**Sydney Metro Pitt Street North OSD  
Stage 1 Modification (SSD 8875 MOD 1) & Stage 2 (SSD-10375)**

## Attachment A

3D Perspective View Stage 1 Envelope

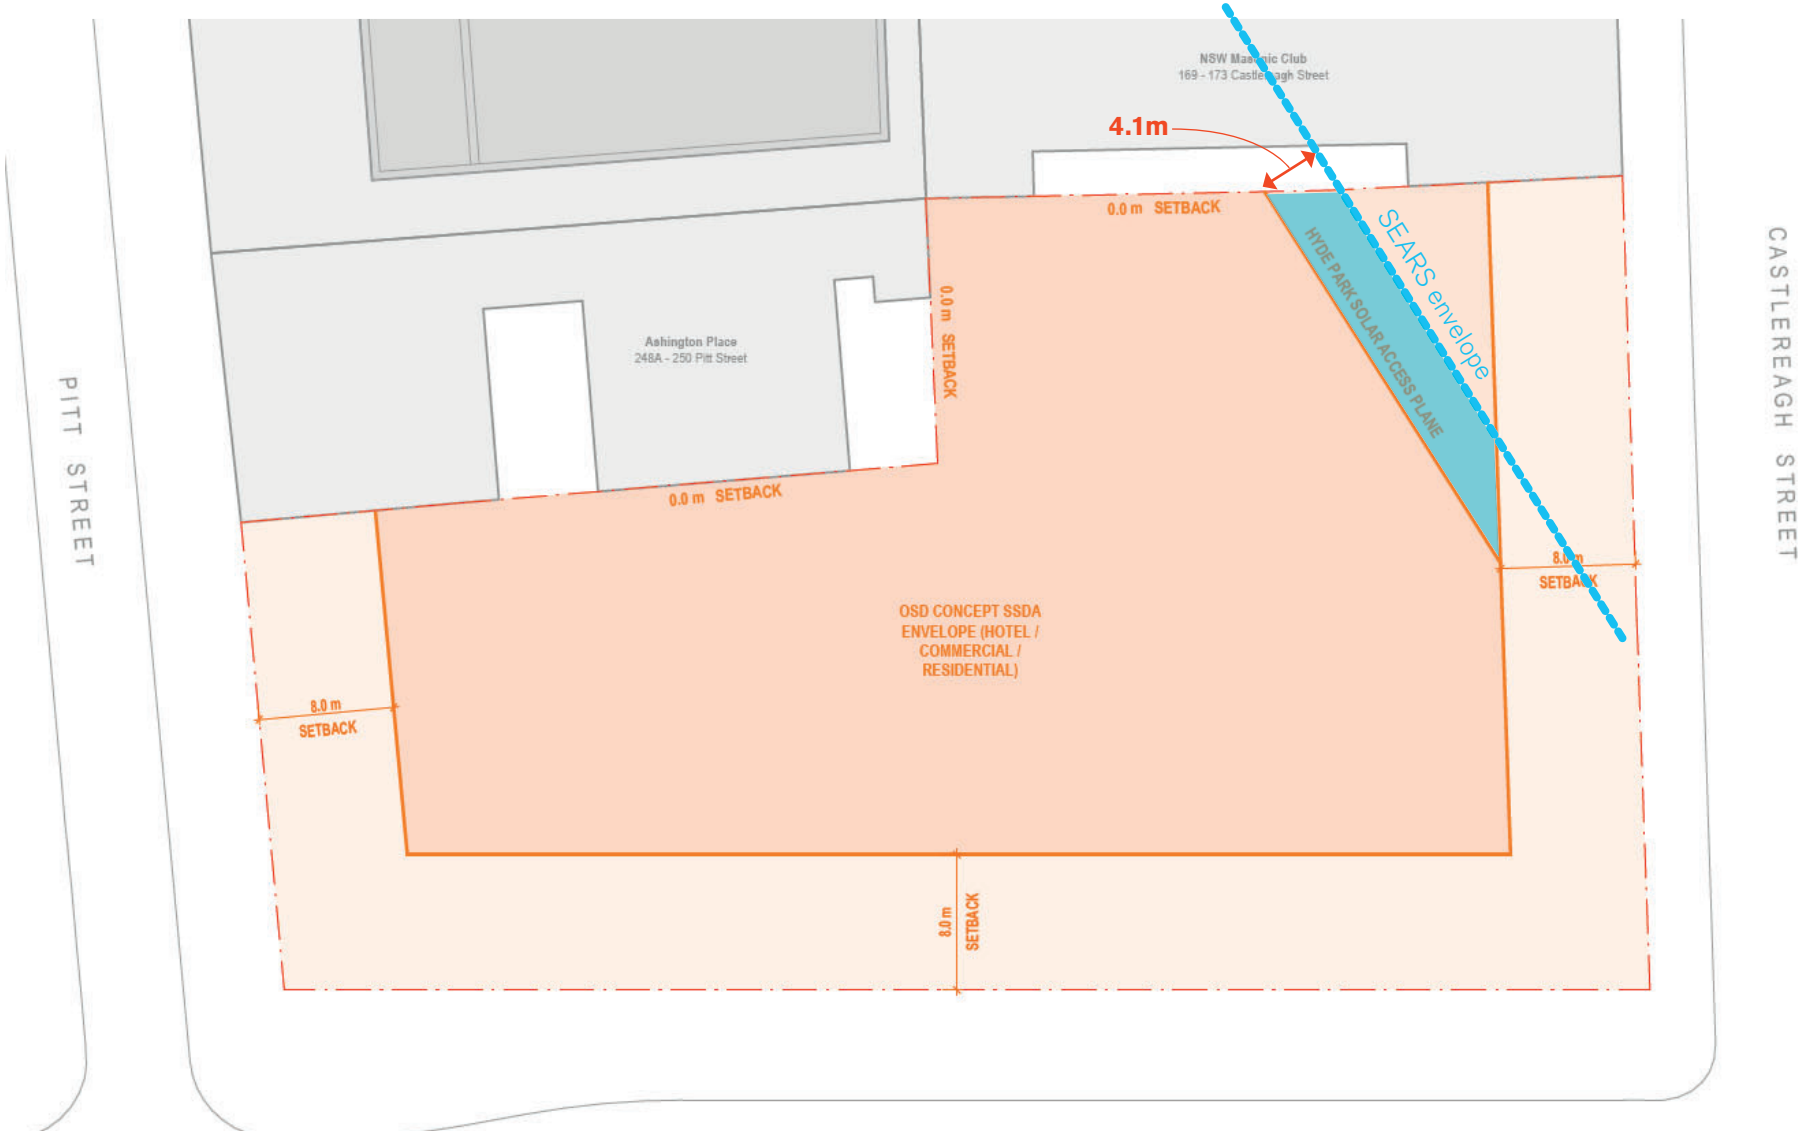
- b. Review the distribution of floor space to minimise external impacts and satisfy the following Design Guidelines requirements:
  - *(6.b) Maximise solar access to the public domain, through responding to the reduced shadow cast by the redevelopment of 201 Elizabeth Street on Hyde Park on June 21st, between 12pm and 2pm - Sydney Metro preliminary design work propose an angled offset of the north eastern corner of 4.1m to achieve this outcome.*

## Comparison Stage 1 Envelope and SSDA Scheme

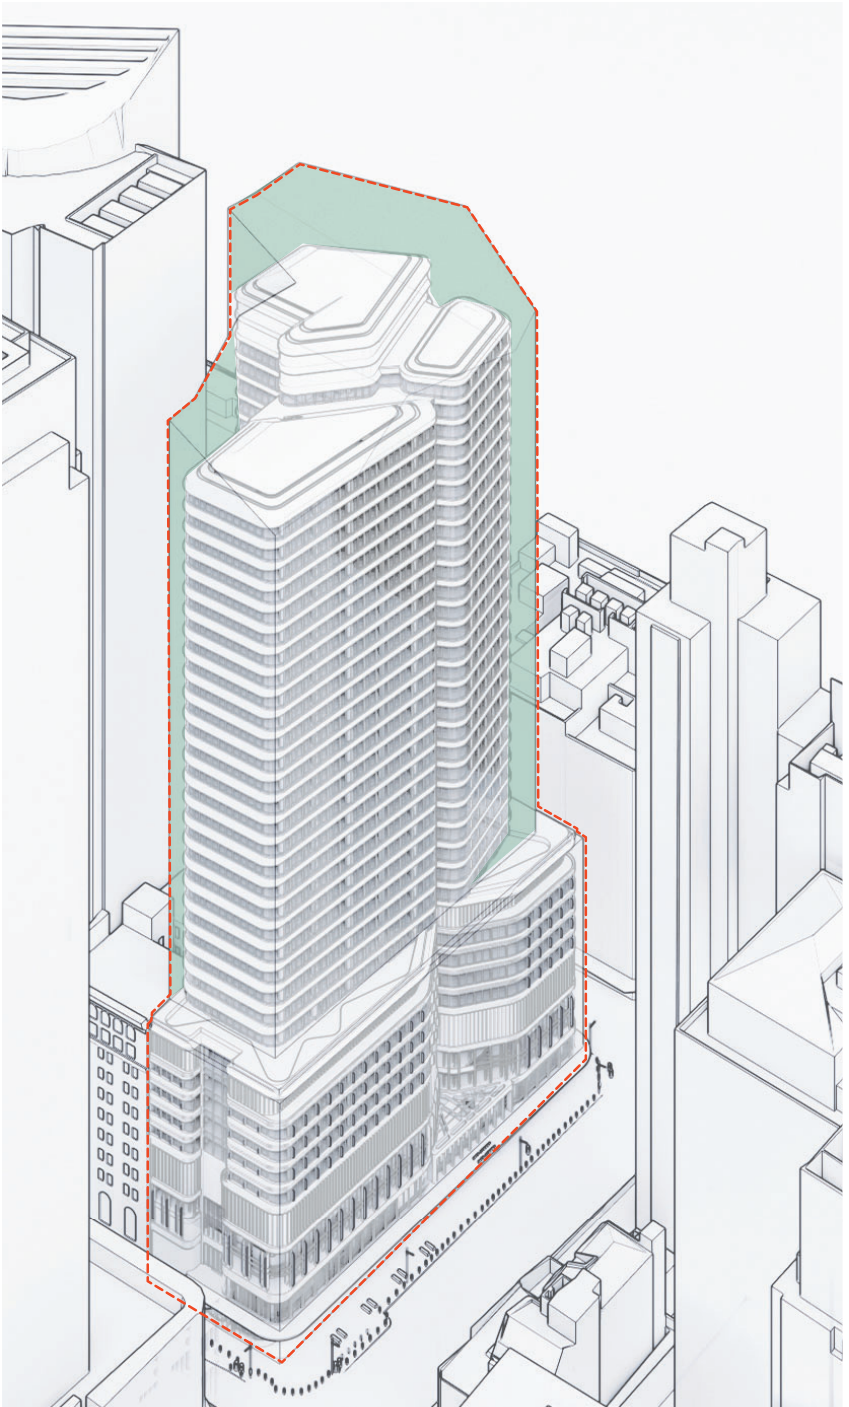
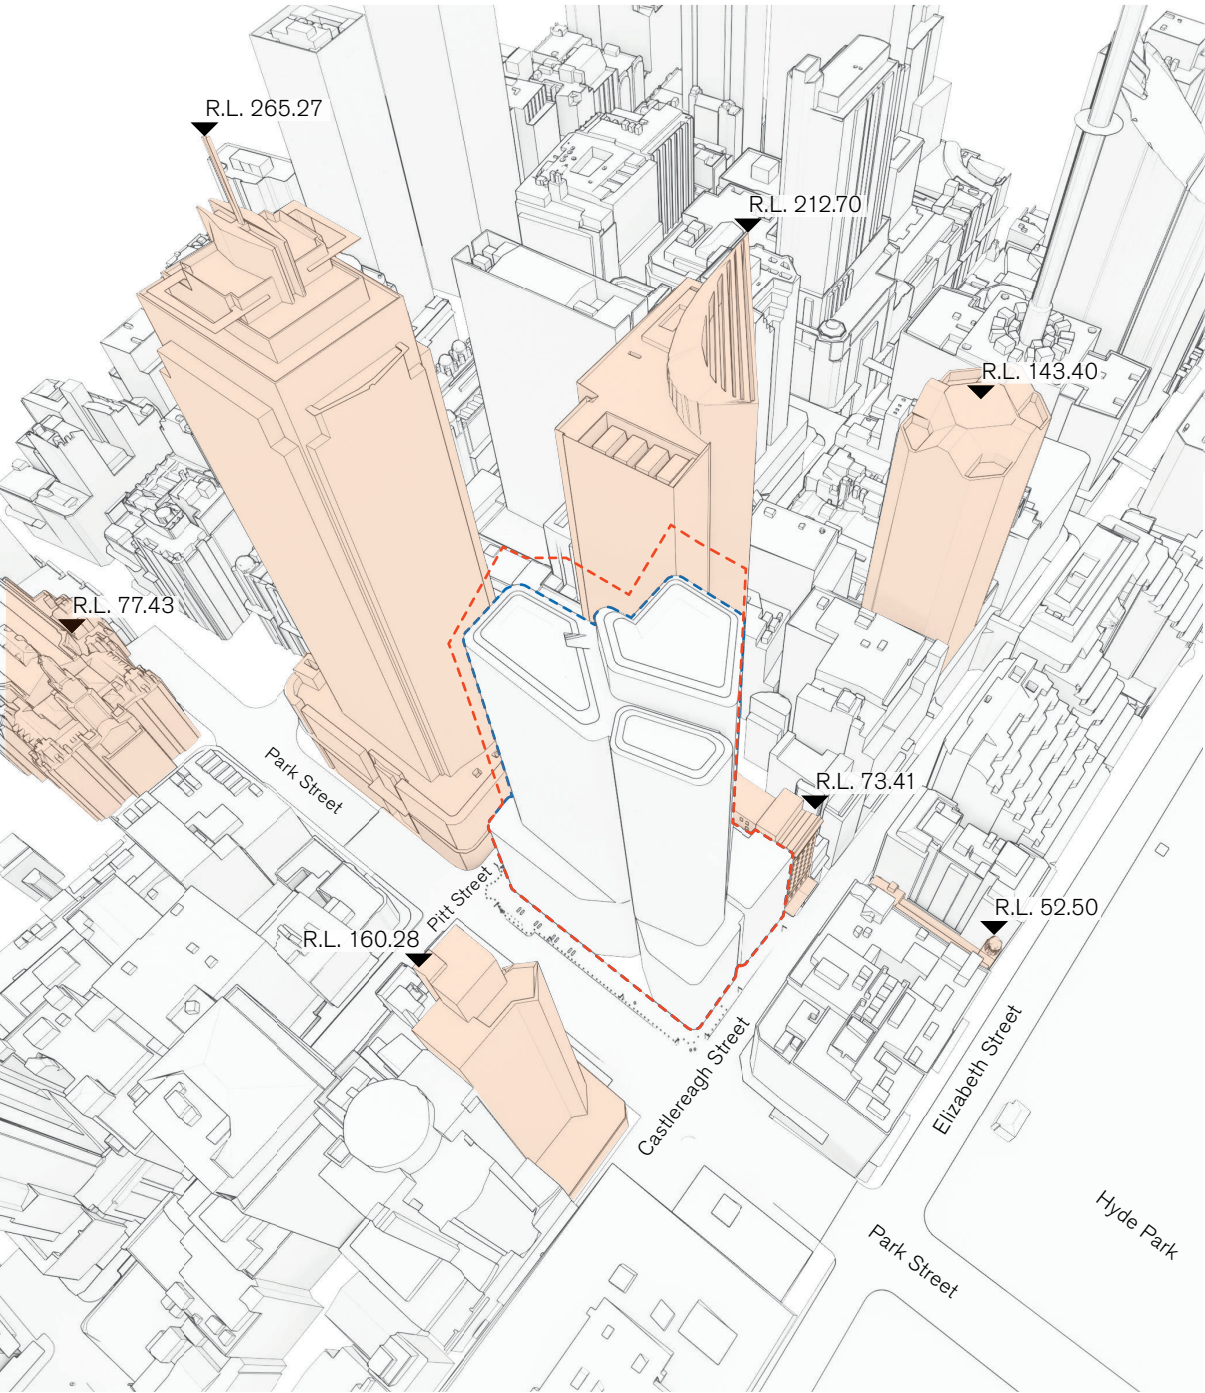
- *(9.c) Minimise overshadowing impacts to surrounding residences, including private residences at 27 Park Street (Park Regis).*
- c. Provide further justification for the proposed floor space and outline the potential for additional public benefits that could be provided as part of the proposal.
